CITY OF ALBUQUERQUE
MUNICIPAL DEVELOPMENT DEPARTMENT
ENGINEERING DIVISION/DESIGN HYDROLOGY SECTION

PRE-DESIGN CONFERENCE RECAP

REF: MARTINEZ 4-PLEX (J11-D21) RECEIVED AUGUST 30, 1985

REF: REVISED DRAINAGE PLAN FOR MARTINEZ 4-PLEX (J11-D21) RECEIVED
SEPTEMBER 12, 1985

DRAINAGE PLAN FOR
4- PLEX
520 59th. STREET, N.W.
LOT 14, E.B. WHITE ADDITION

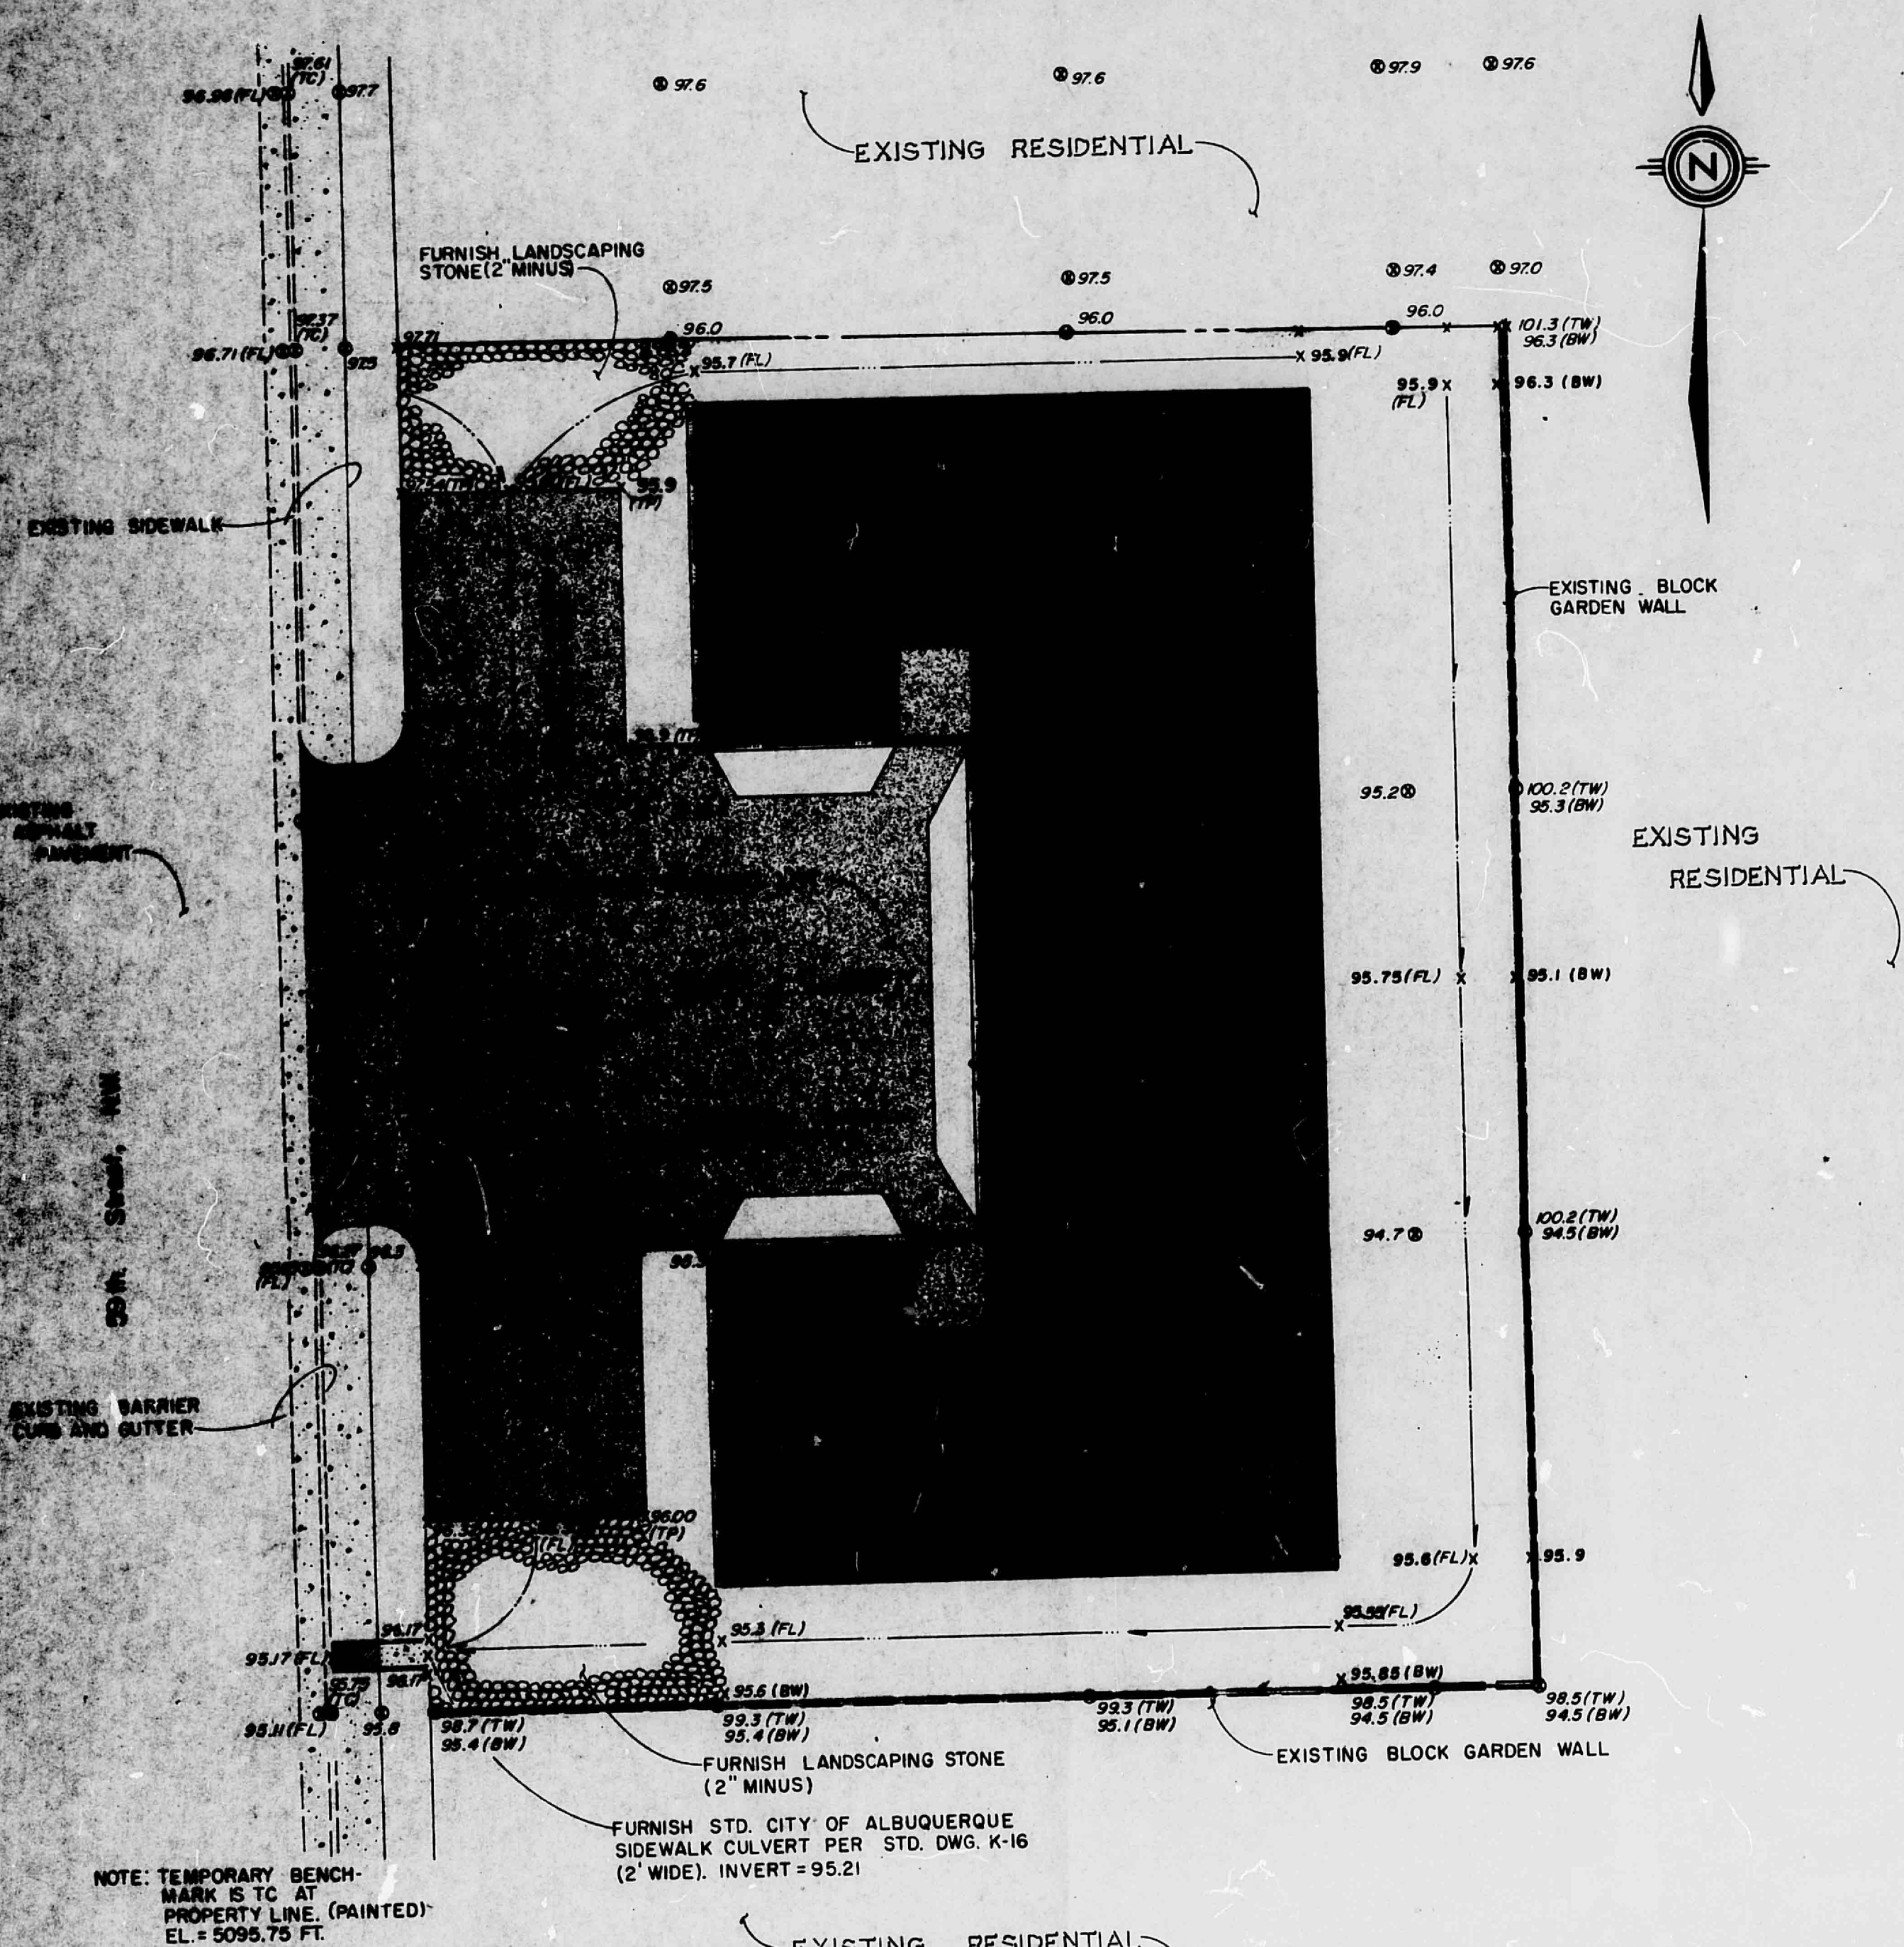
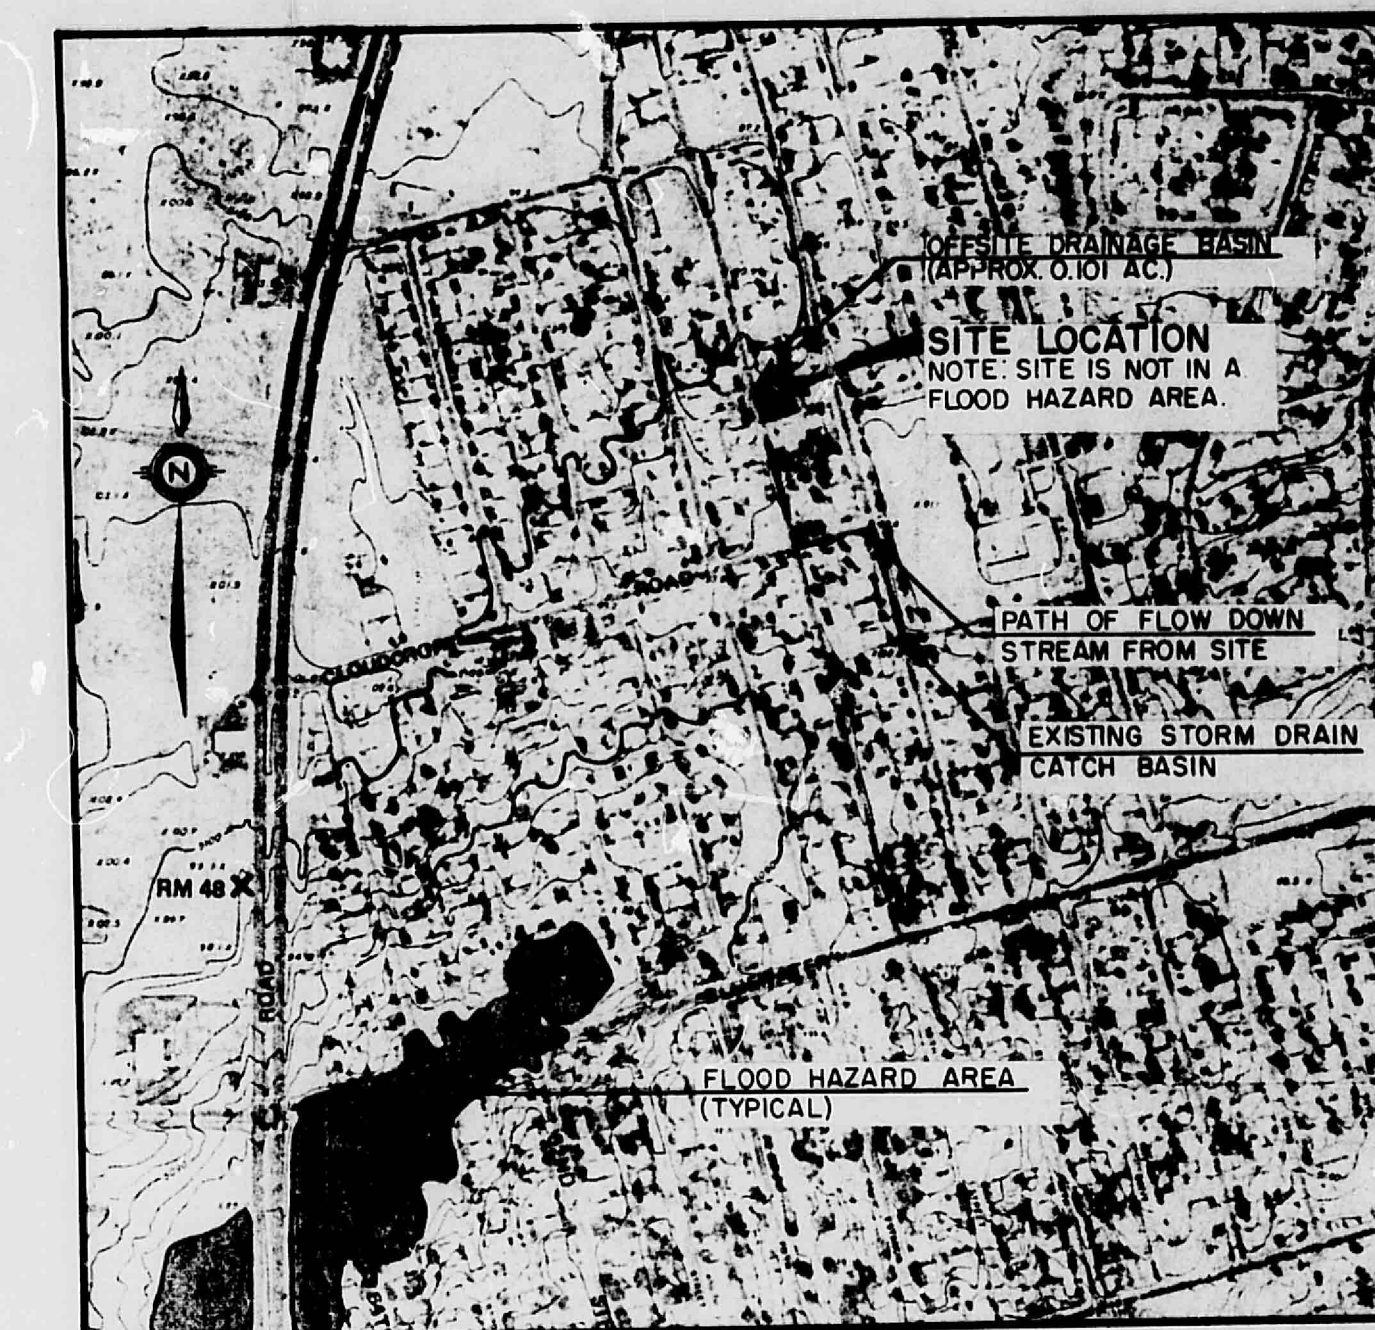
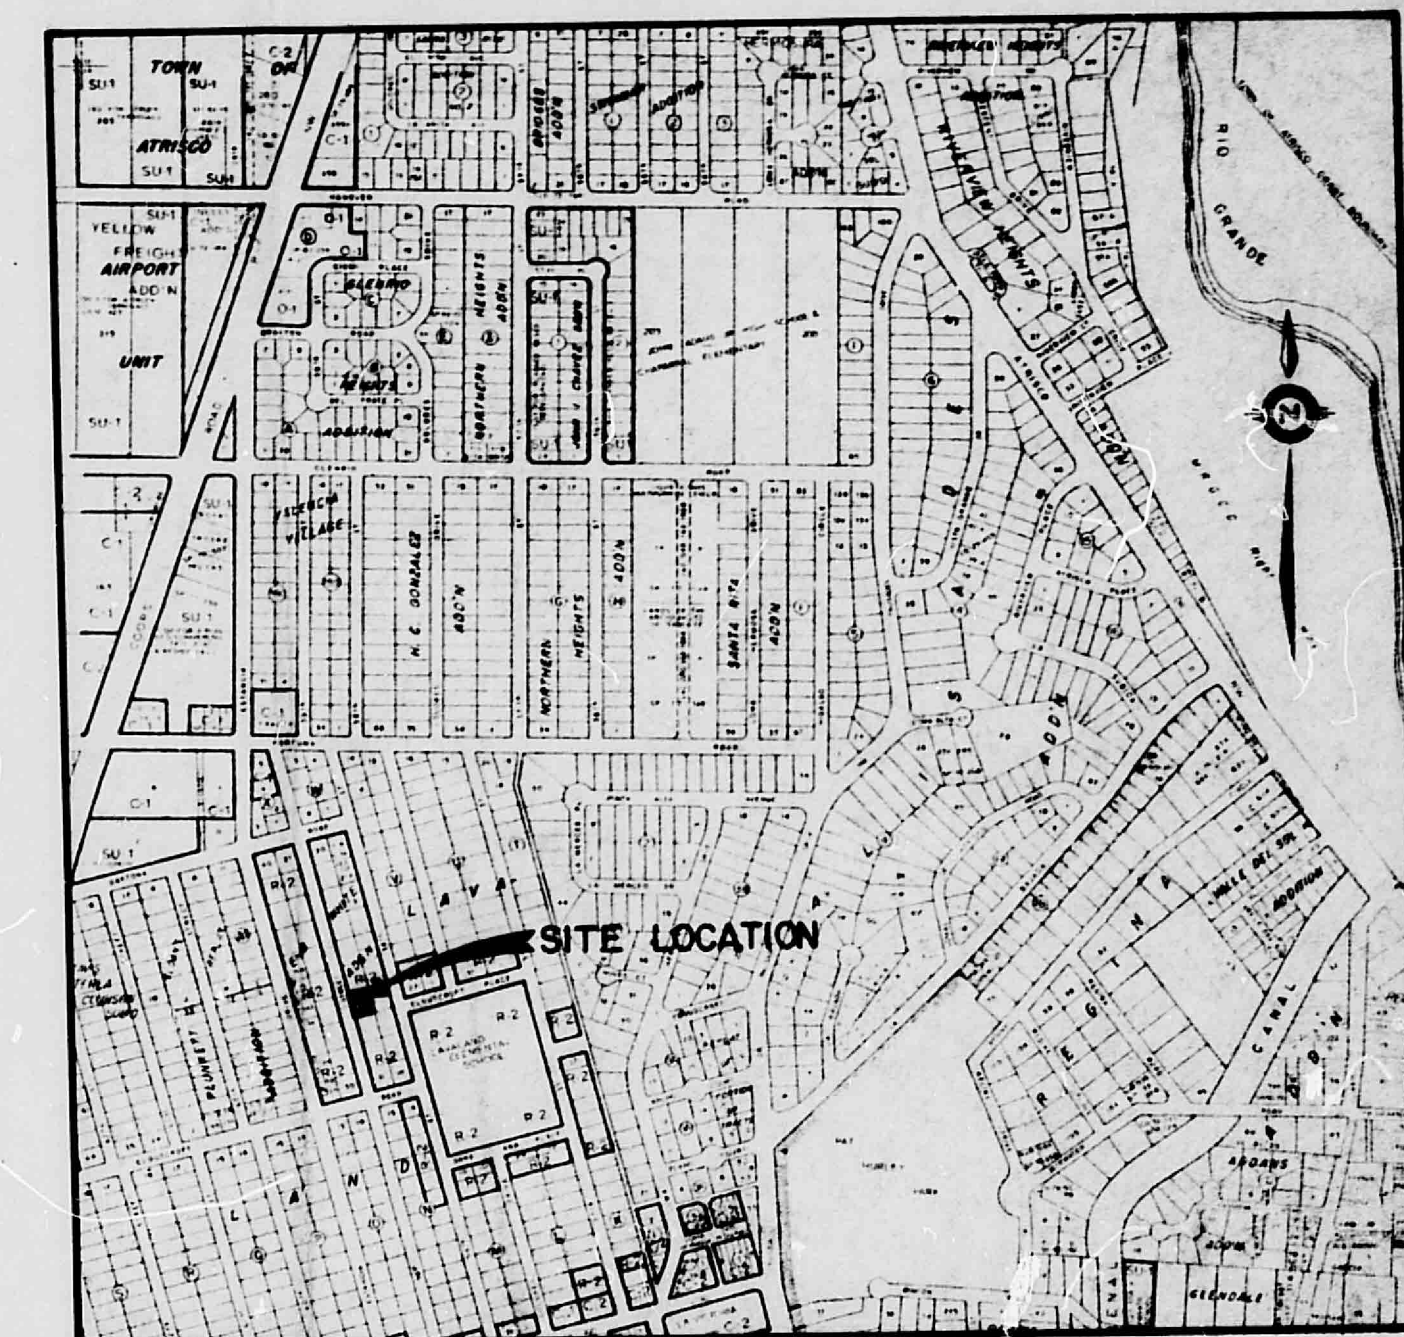
1. Off-site flows - quantification and/or location or treatment. Proposed site must accept off-site flows and pass them through. You indicate a proposed retaining wall which will block the flows on the north side.

1. TBM location. Must be identified as a curb notch or painted.
2. Finished floor elevation with complete MSL designation.
3. Location and/or direction of flow for roof-drains.
4. Erosion Control Plan.

1. New information sheet with resubmittal designation.
2. Engineer's stamp with signature and revision date.
3. Reason for asking for the location and direction of roof-drains is so that we will be able to tell if any ponding will take place within buffer landscaped zones separating landscape with asphalt areas. In this particular site, the area adjacent to the west side of the proposed buildings is of concern.

4. In answer to your comment pertaining to the requirement of an erosion control plan, granted the DPM on page 112 does make such statement, the Drainage Ordinance under Section 12-2 Drainage plans: A short detailed presentation required for approval of small, simple development approvals. Drainage plans are prepared with or on the detailed grading plan and address both on-site and off-site drainage control, flood control and erosion control issues. Drainage plans are required for building permits, site developments involving less than five (5) acres. In this particular instance an erosion control statement identifying that the contractor will be responsible for any importation of sediment from the site onto the City R/W.

5. Please include your undeveloped flow rate calculations within your plan drawing.

- ° Closer inspection of the original submittal may reveal proposed grading provided for passage of off-site flows. However, we have made slight adjustments to the grading plan, including removal of the retaining wall, to make the acceptance and passage of off-site flows more obvious.

- ° Done
- ° Done
- ° Per item 24-D, page 109 of the DPM the internal contributory drainage areas, including roof areas (in this case the proposed building site) have been outlined. However, the DPM does not specify that the location and/or direction of flow for roof-drains be indicated on the plan drawing. In addition, cursory inspection of this drainage plan shows the locations of roof drains would not be of significance because positive drainage is provided all around the proposed building site.

- ° According to paragraph one, page 112 of the DPM an erosion control plan is not required with this submittal because:
 - a. the site is considerably less than 1.0 acres.

- b. the site requires considerably less than 500 cubic yards of grading.
 - c. none of the grading for this site is to be within or adjacent to a water course defined as a major facility during the months of July, August, or September.
